Application by Thurrock Power Ltd for an Order Granting Development Consent for the Thurrock Flexible Generation Plant Project

Response to Procedural Deadline D

Specialist Archaeological Advice

20/00273/DCO Thurrock Flexible Generation Plant, Fort Road, Tilbury

Figure 1
ZTV and heritage designations

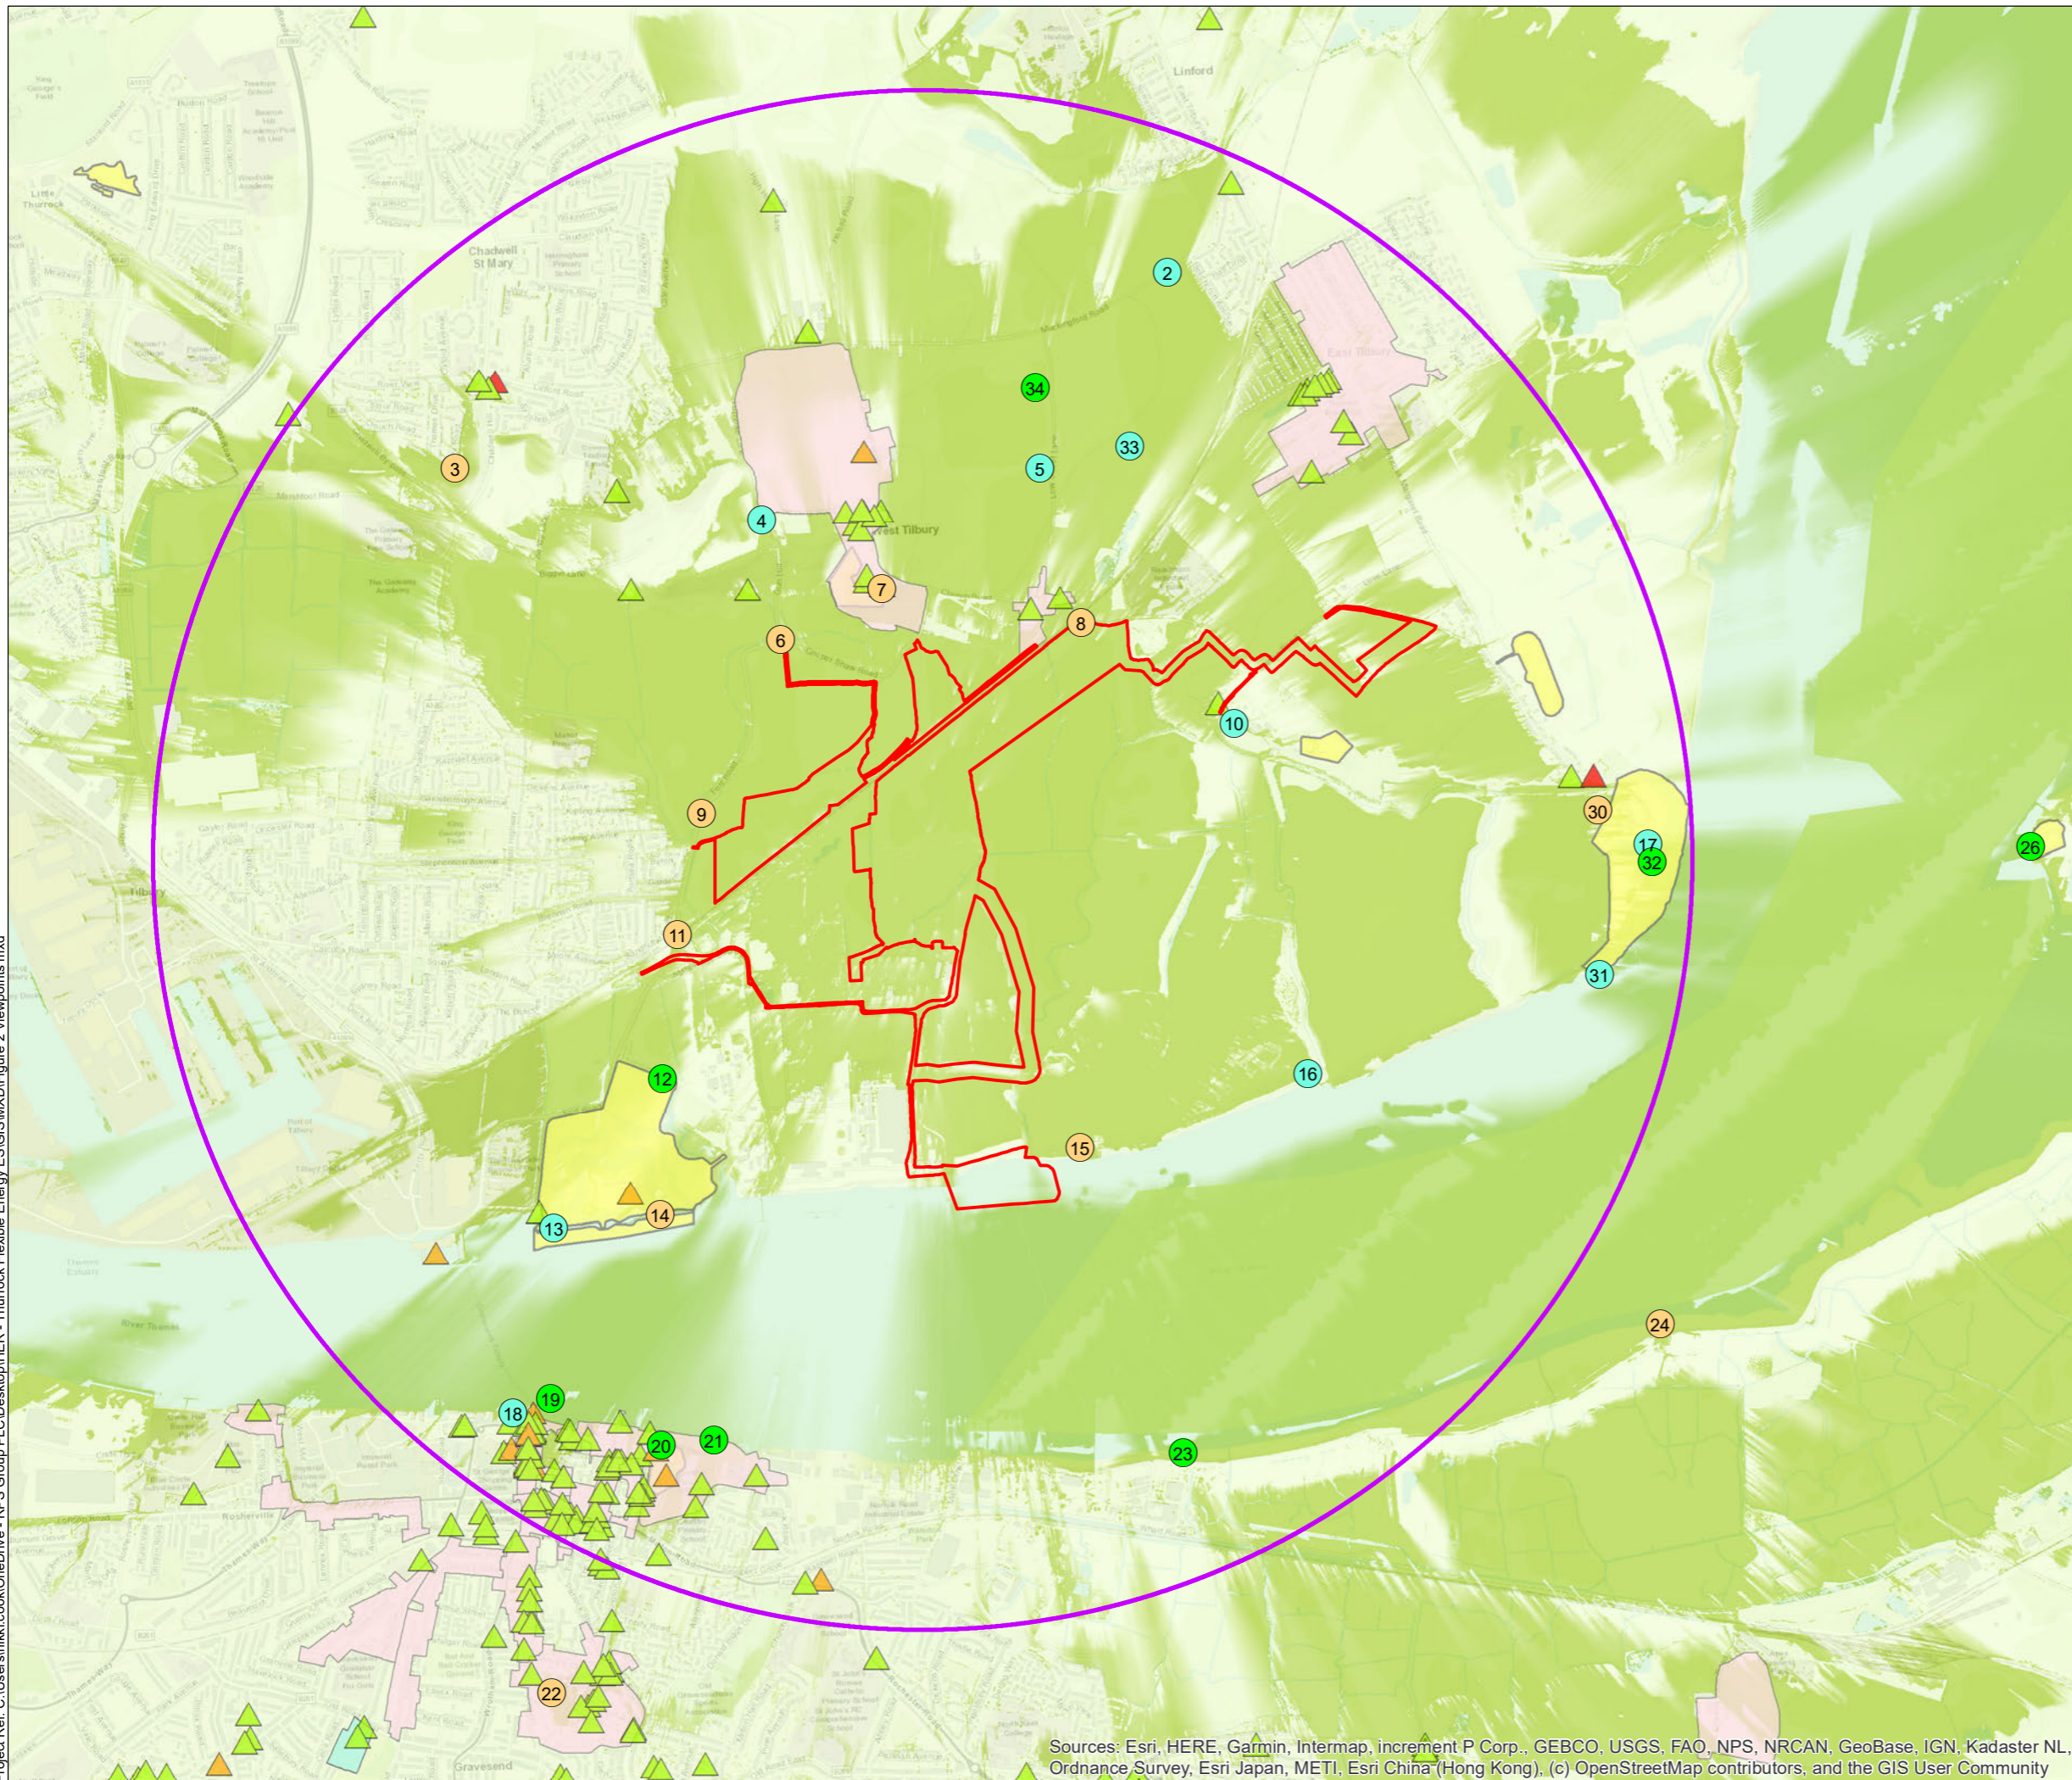
- Reference has been made to figures/viewpoints within the LVIA in Appendix 1, however there are still a number of heritage assets from which viewpoints/photomontages/wireline images have not been taken. Additional plates have been included within the settings assessment document, however some of these show only the heritage asset itself and do not allow for an assessment of how setting contributes to significance.

Detailed gradiometer survey results: interpretation

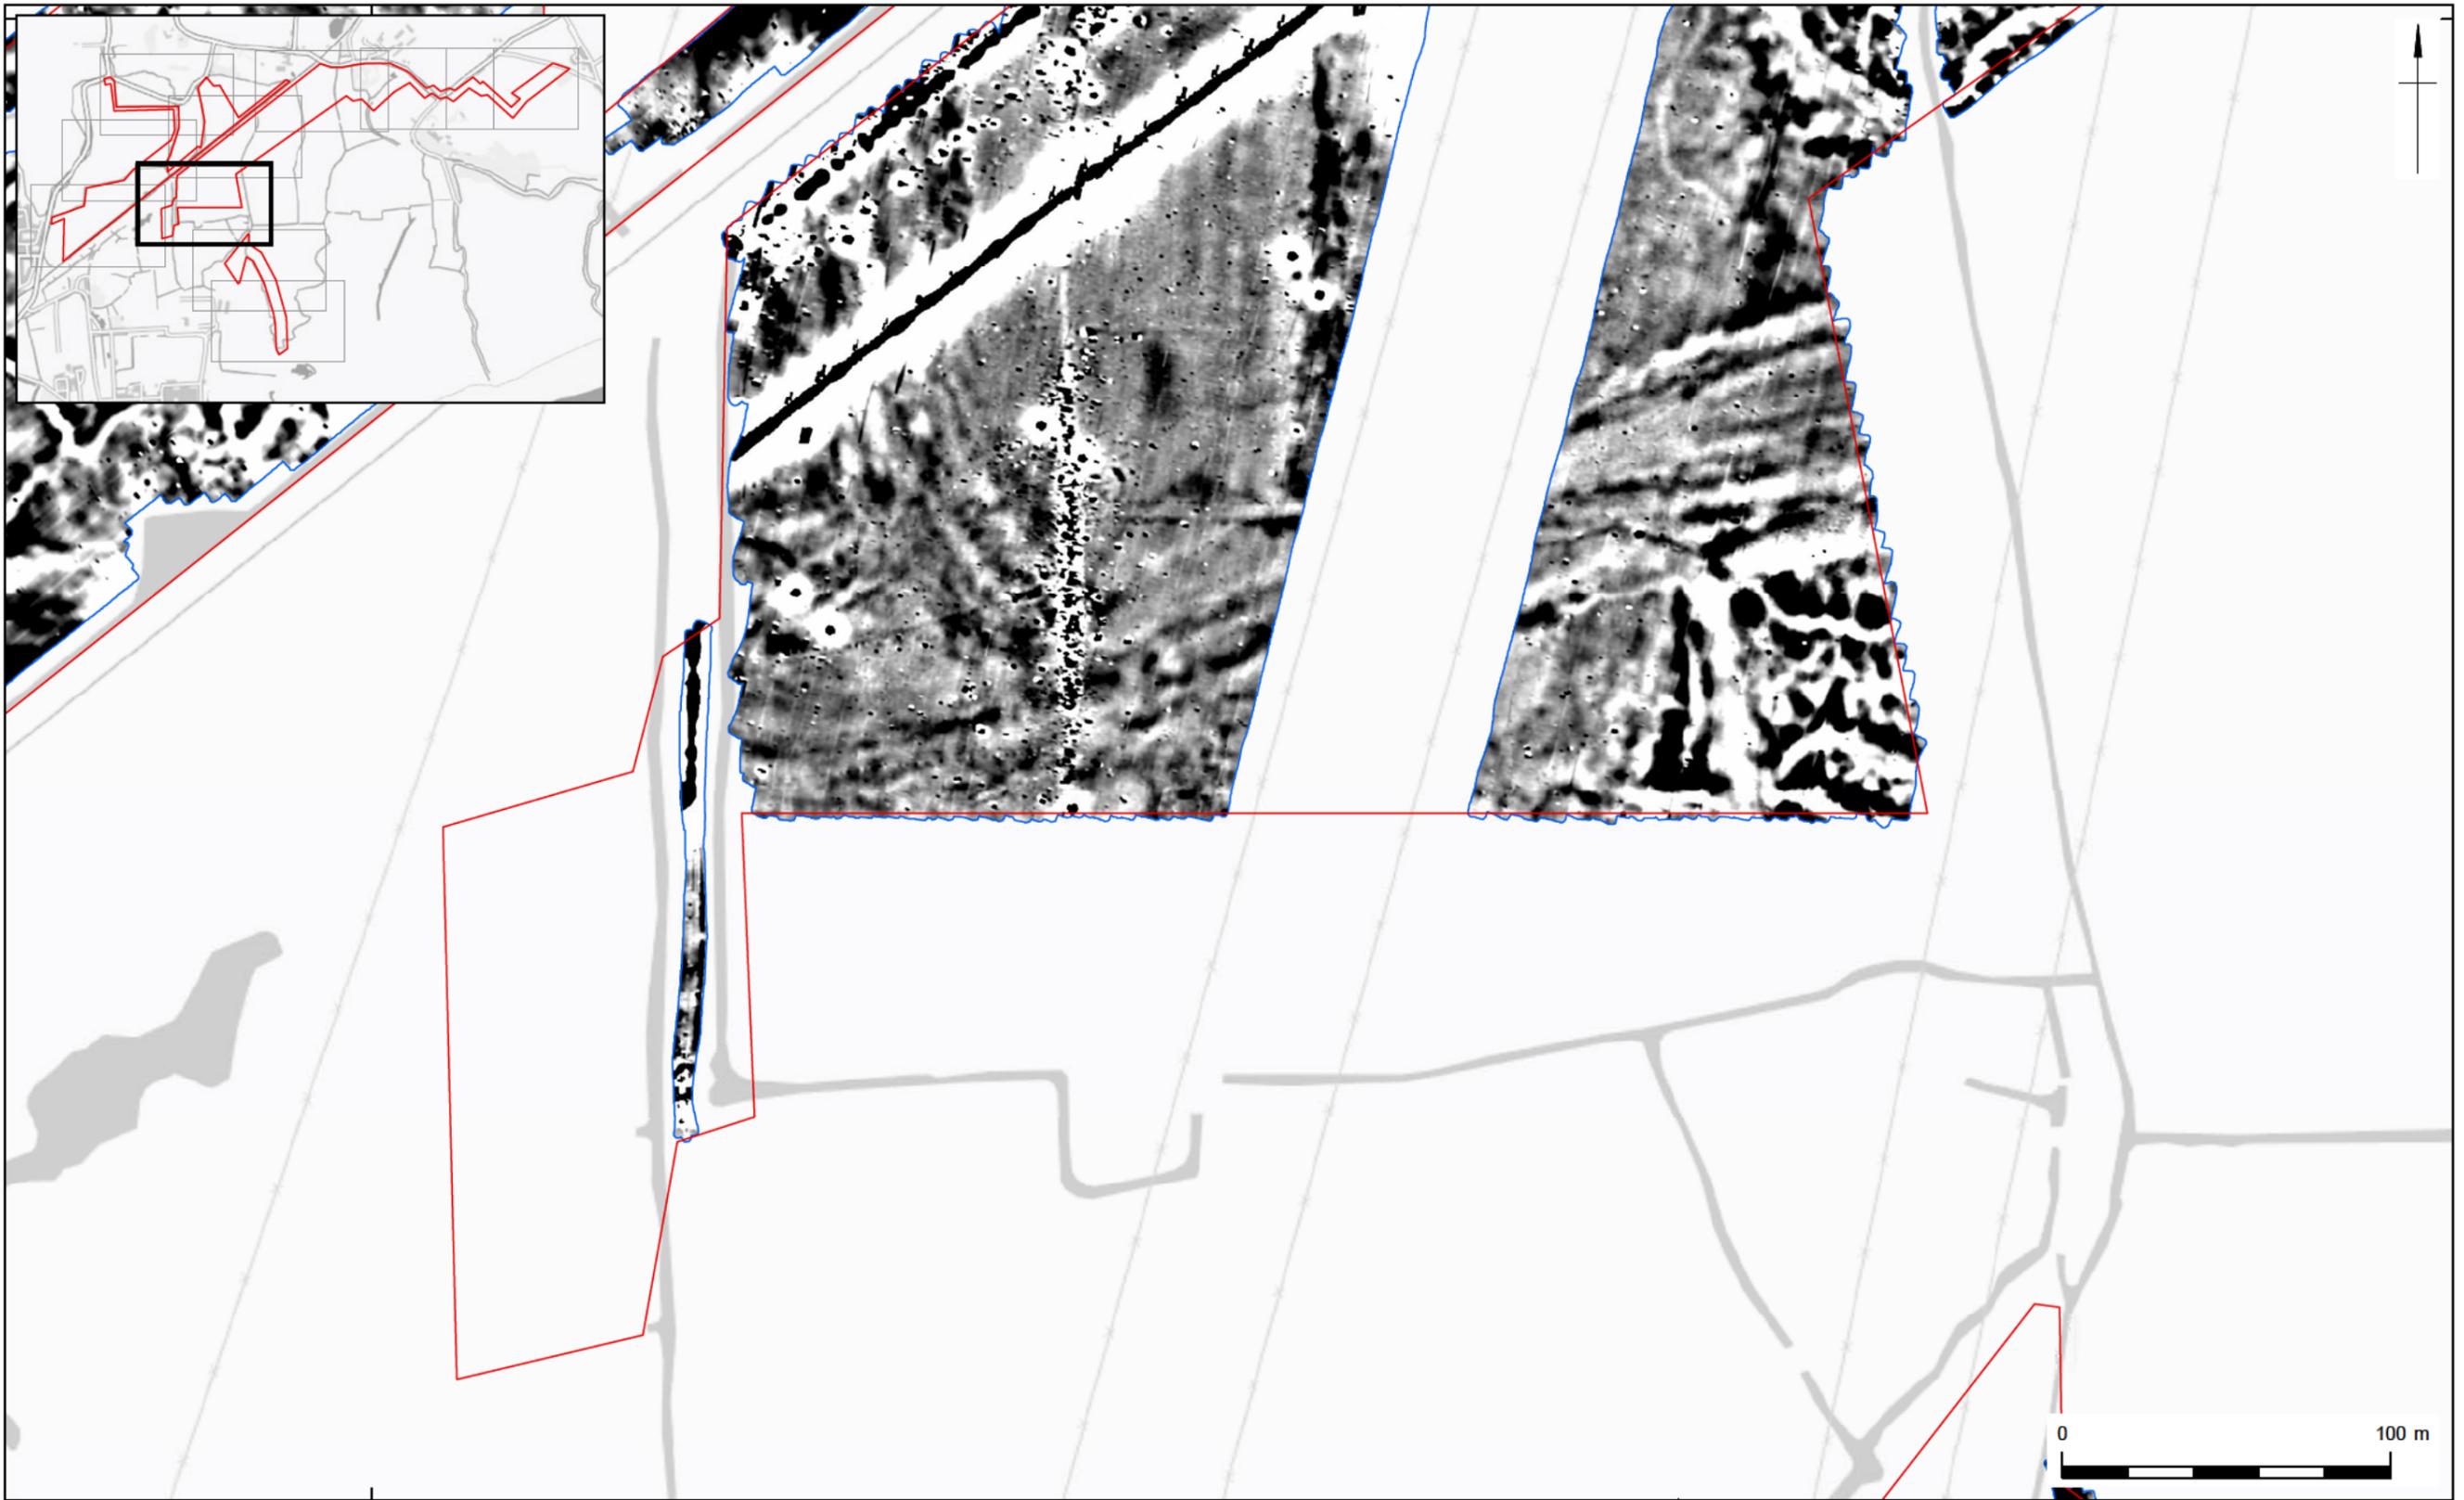
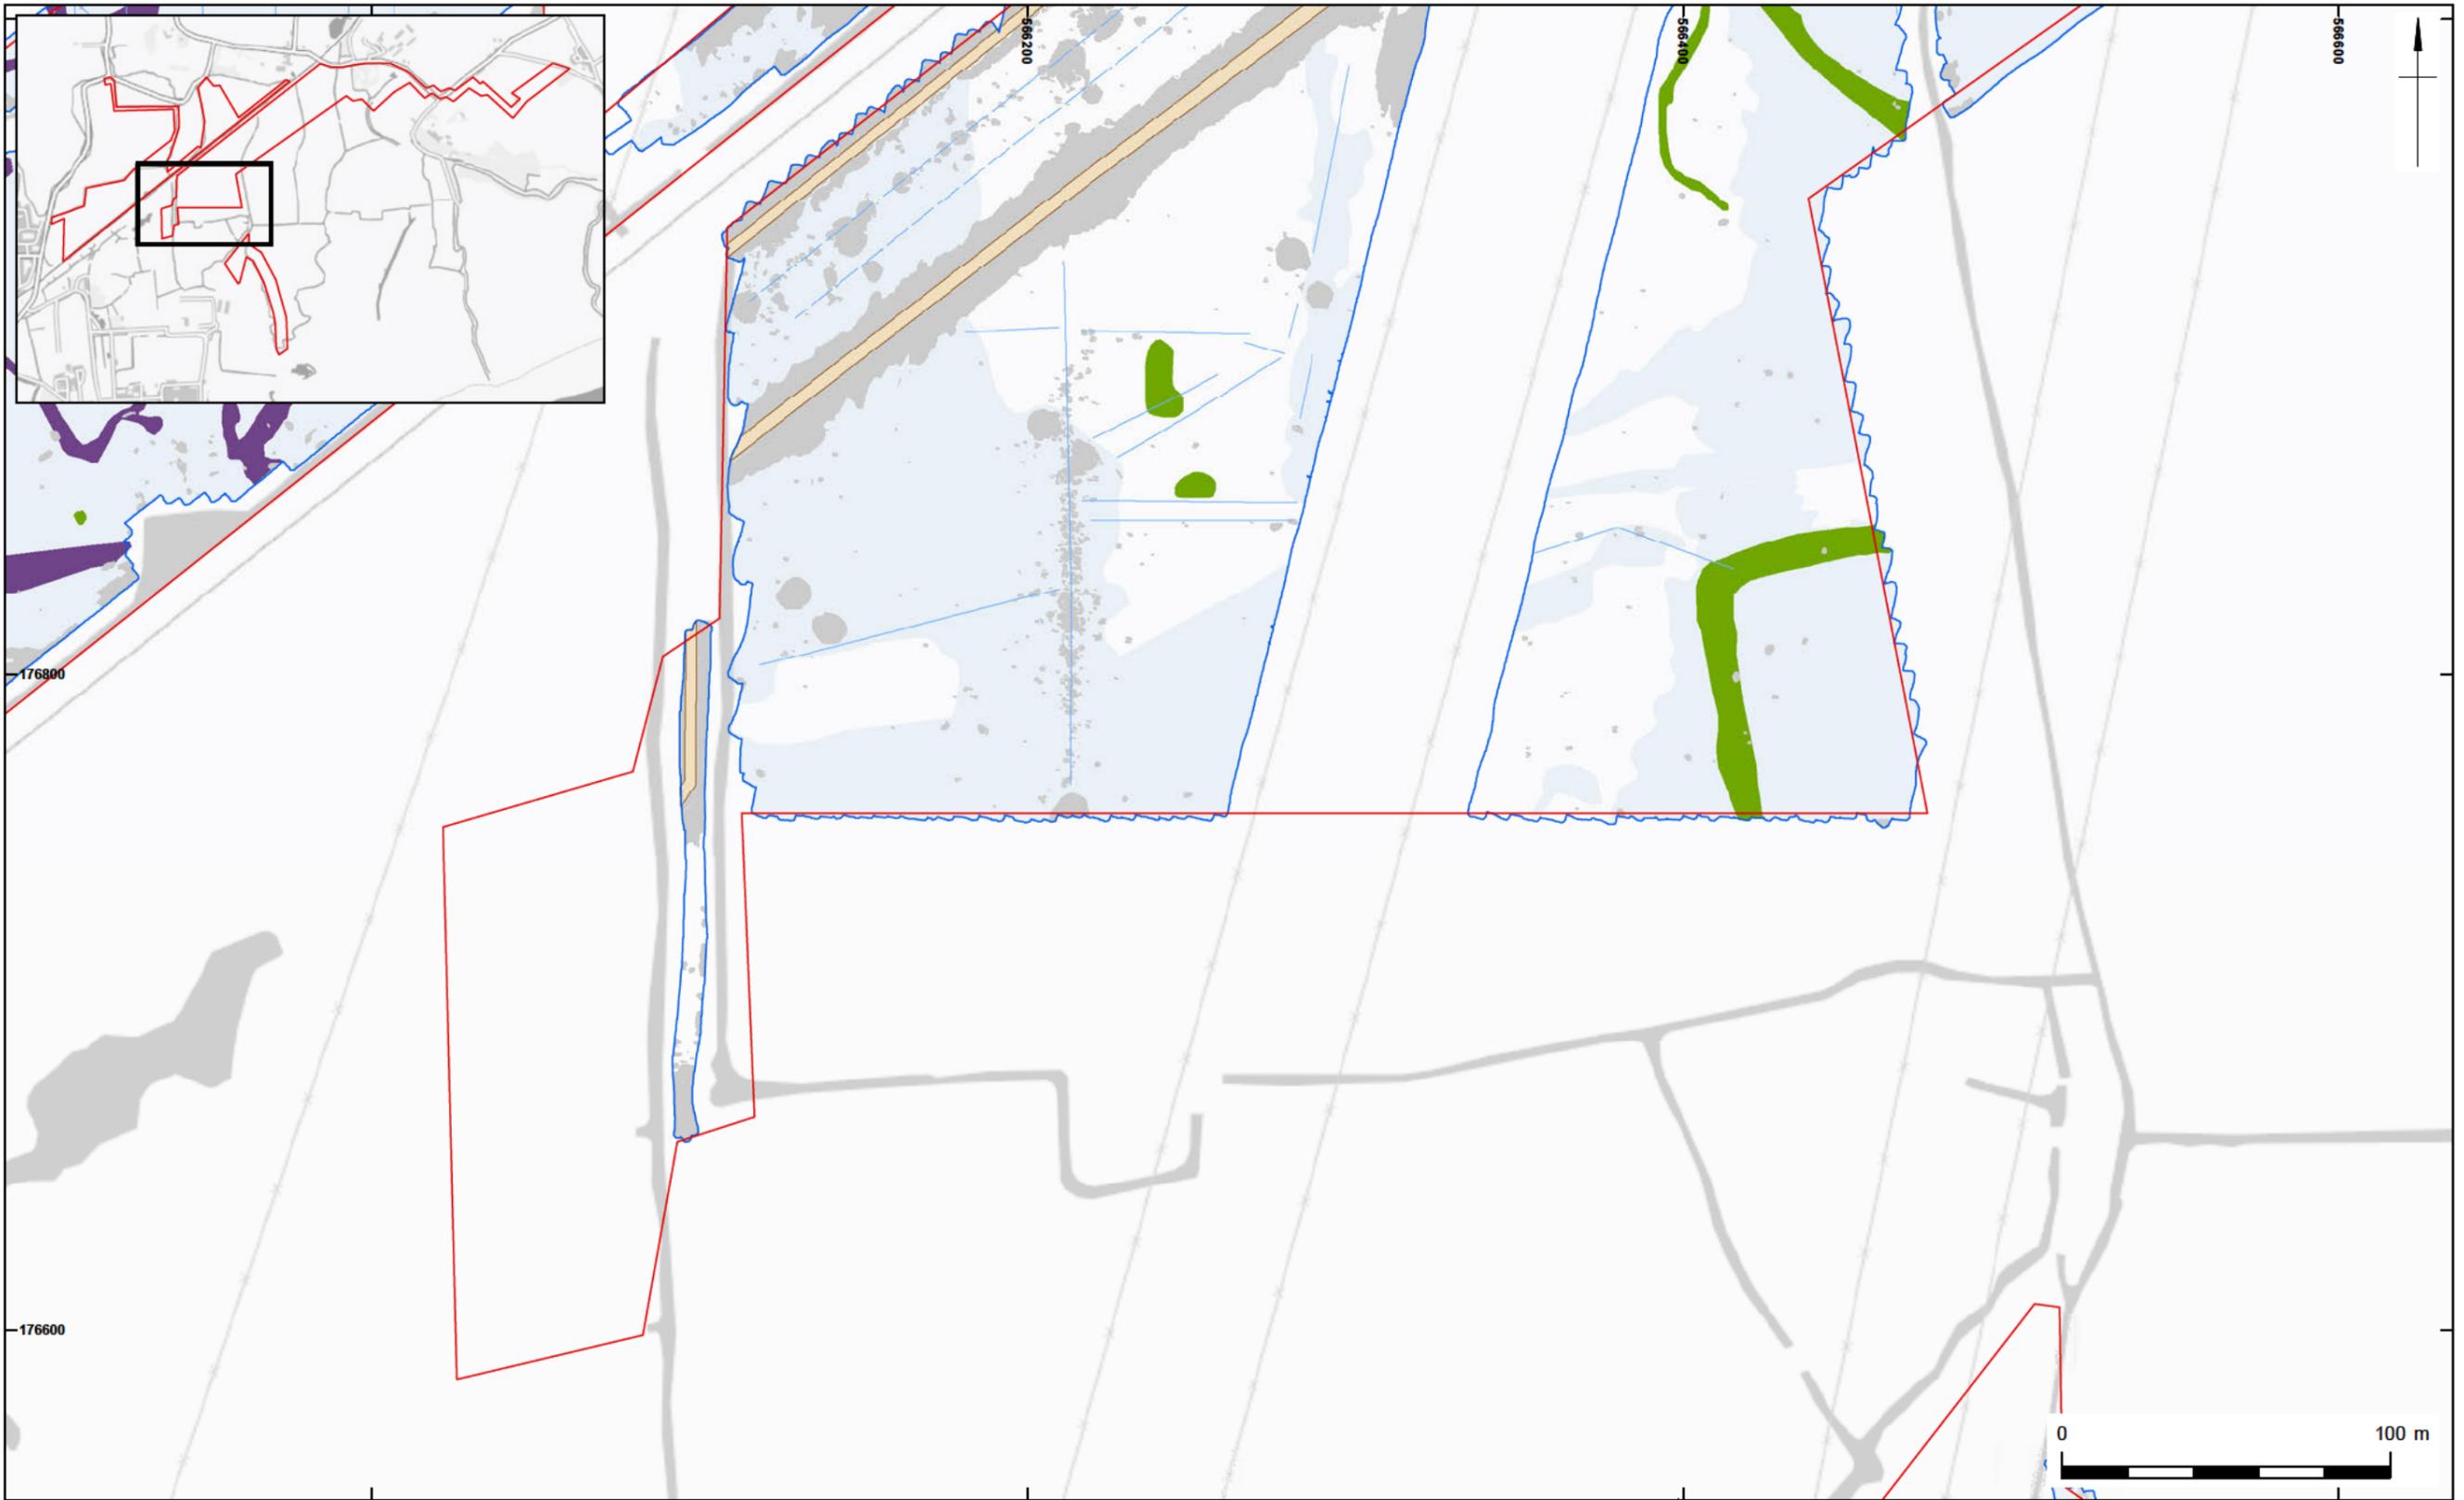
It is pleasing to see that in the documents provided in December that geophysical surveys have been undertaken on the majority of the development area. This provides basic data which can be built on to facilitate an understanding of the historic environment so that the inspector can make an informed decision on the impact of the development. It is disappointing that the applicant does not have the detailed results of the geophysics as the present document provides little detail on the results.

These results also need to be ground truthed to have an understanding as to what the features represent. Large scale developments in the area have shown extensive red hill (saltern) complexes surviving within the grazing marsh area. Similarly, the Lower Thames trial trenching, being undertaken to support their DCO submission has shown an extensive archaeological site of Roman date at the eastern end of this application.
